SUBJECT: Wake County; Division 5; NC 55 Widening to a Multi-lane facility from  
SR 1108 (Wake Chapel Road) to SR 1114 (Ralph Stevens Road); State  
Project No. 8.1403501; Federal Aid Project No. STP-55(5);  
TIP Project No. R-2907

Re: Certification Pursuant to Section 401 of the Federal Clean Water Act and Neuse Buffer Certification, Modification to the improvements to NC 55 widening, from SR 1108 (Wake Chapel Road) to SR 1114 (Ralph Stevens Road) in Wake County, TIP R-2907, Federal Aid Project STP-55(5), State Project No. 8.1403501, WQC Project No. 010681.

Attached hereto is a modification to Certification No. 010681 issued to the North Carolina Department of Transportation on April 25, 2002. The attached modification authorizes the following:

PROJECT REFERENCE NO. R-2907	SHEET NO. 11
R/W SHEET NO.	
ROADWAY DESIGN ENGINEER JOHN C. LANGFORD	HYDRAULICS ENGINEER RALPH STEPHENS
PROFESSIONAL SEAL 15825 JOHN C. LANGFORD	PROFESSIONAL SEAL 18180 RALPH STEPHENS

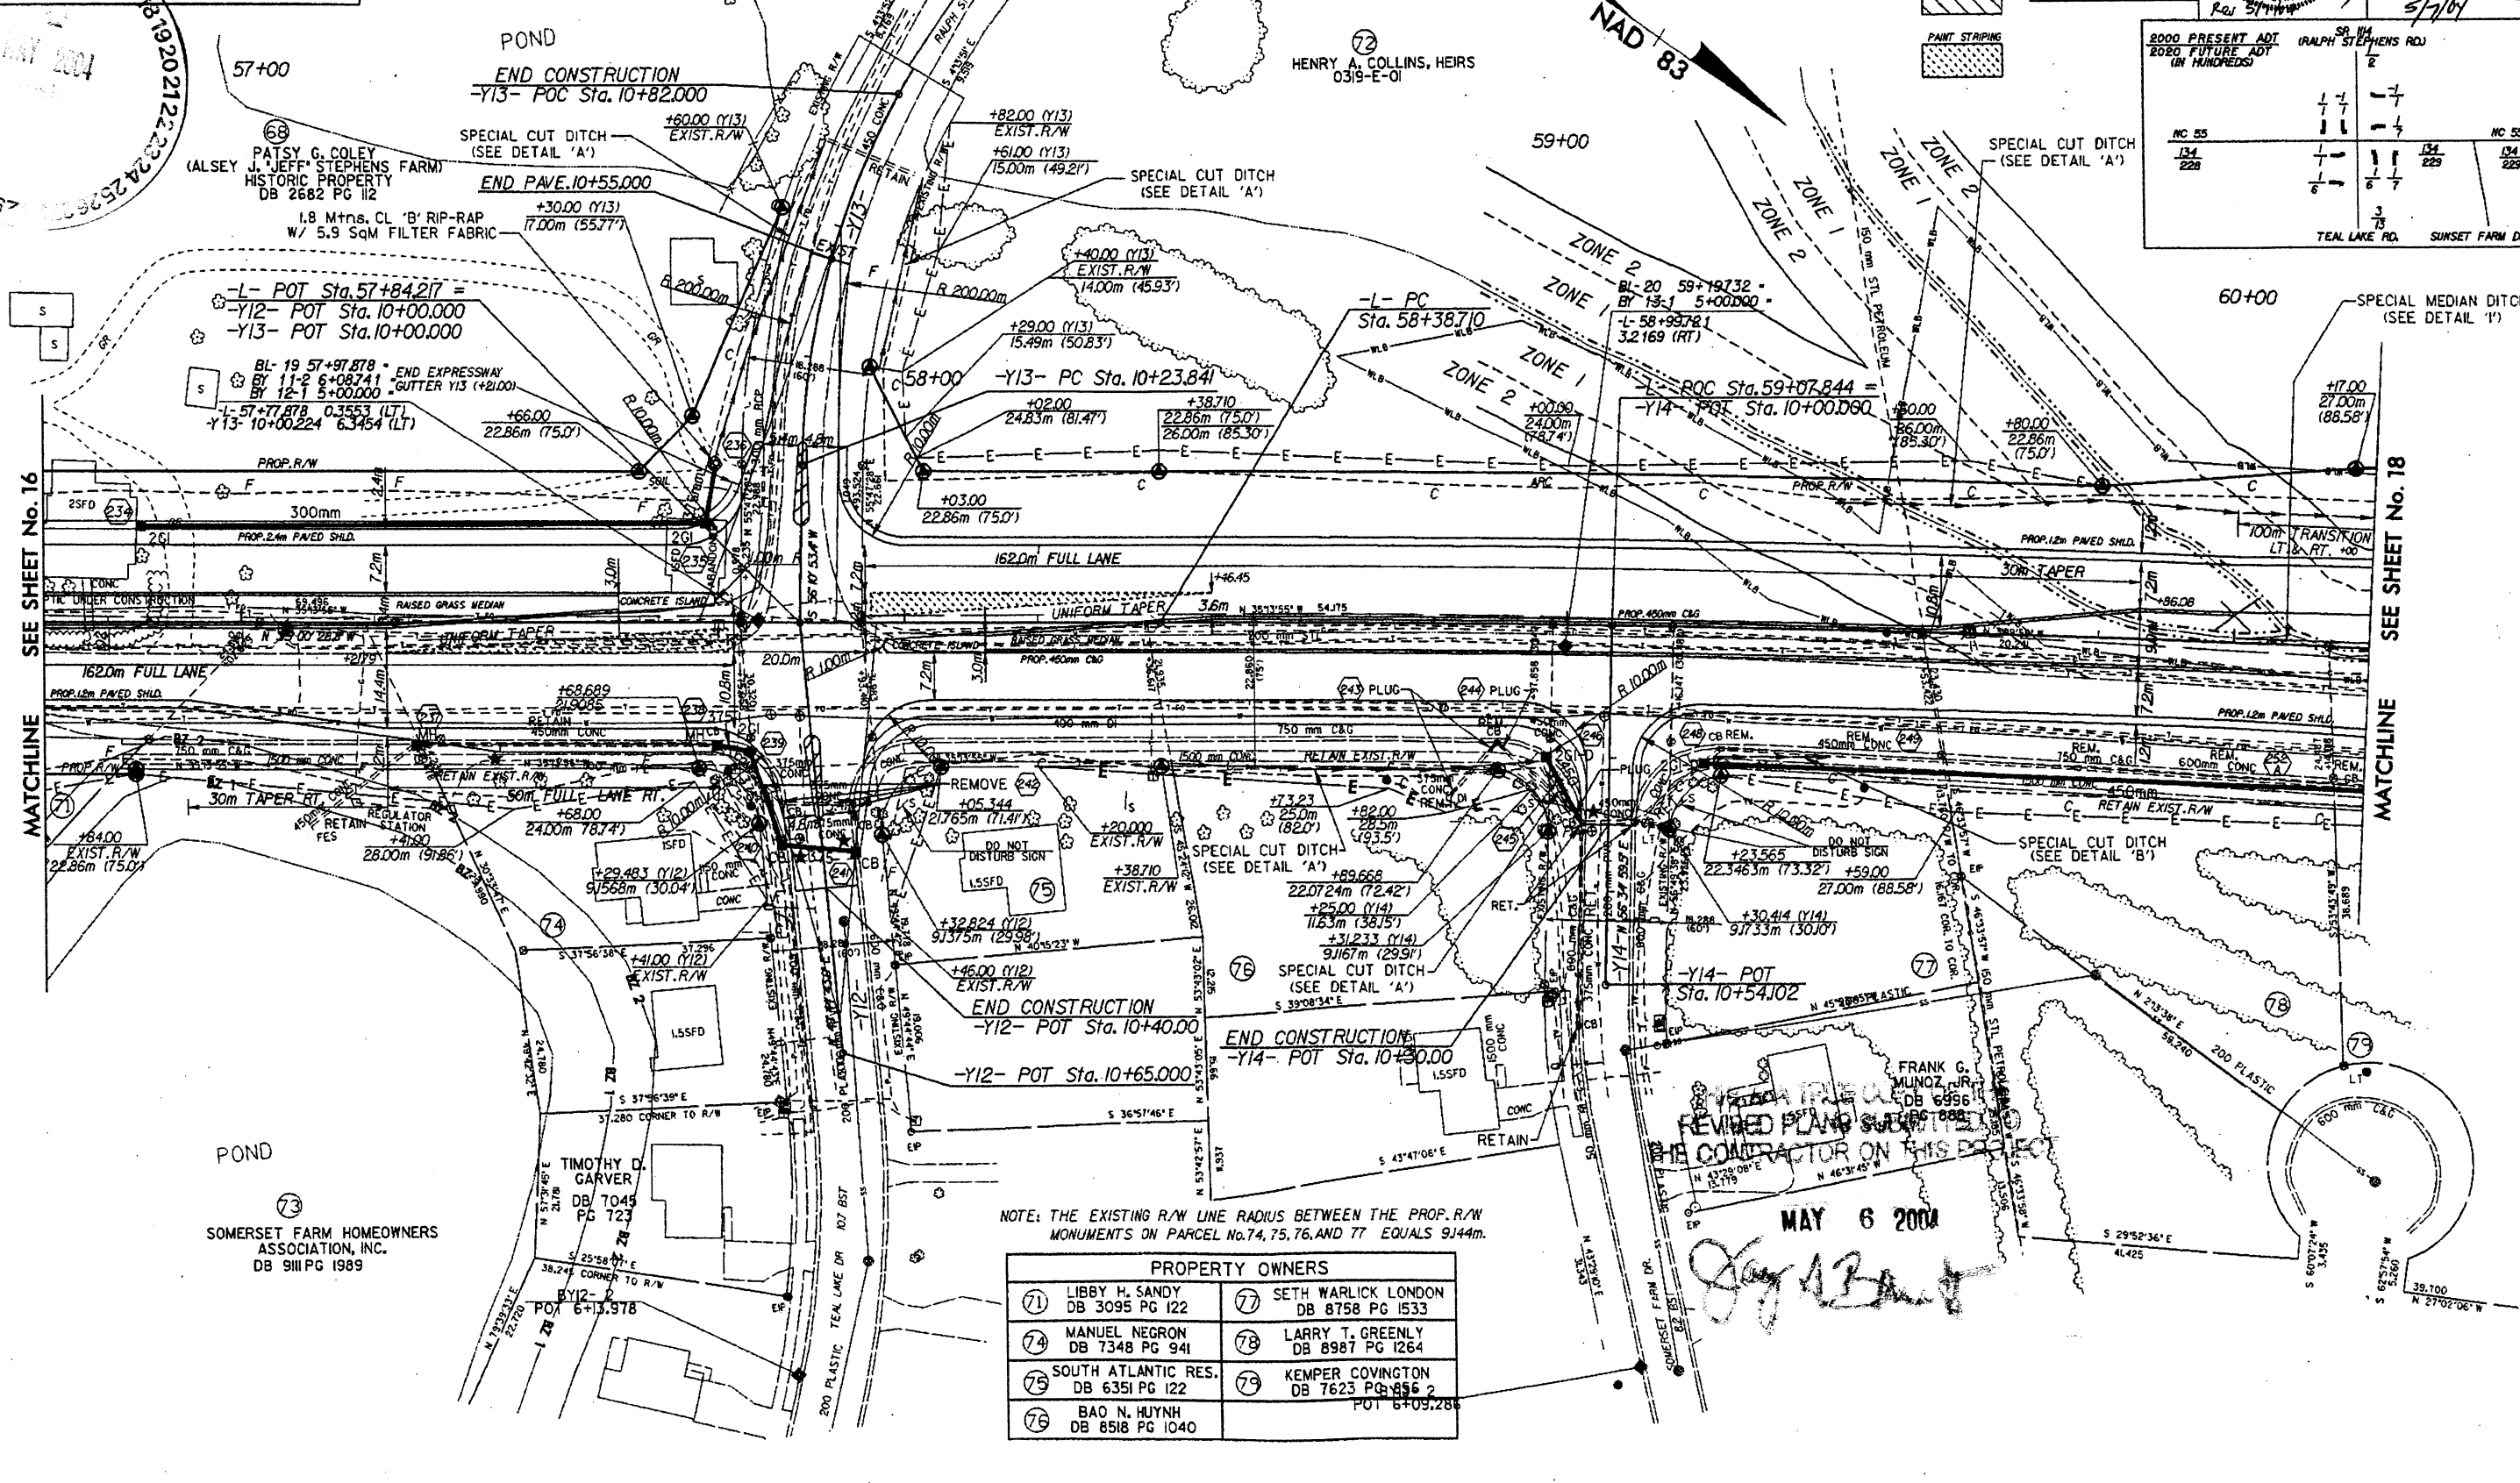
Site Location	Action taken	Impacts
STA 59+60 to STA 60+00	Removal of 300 mm and 375 mm pipe structure and associated catch basins; change in super elevation of left turn lane to drain away from median	None
STA 58+96	Removal of 375mm pipe structure and associated catch basin	None
STA 60+40	Change 900 mm pipe structure with extension to 750 mm pipe structure with extension	None
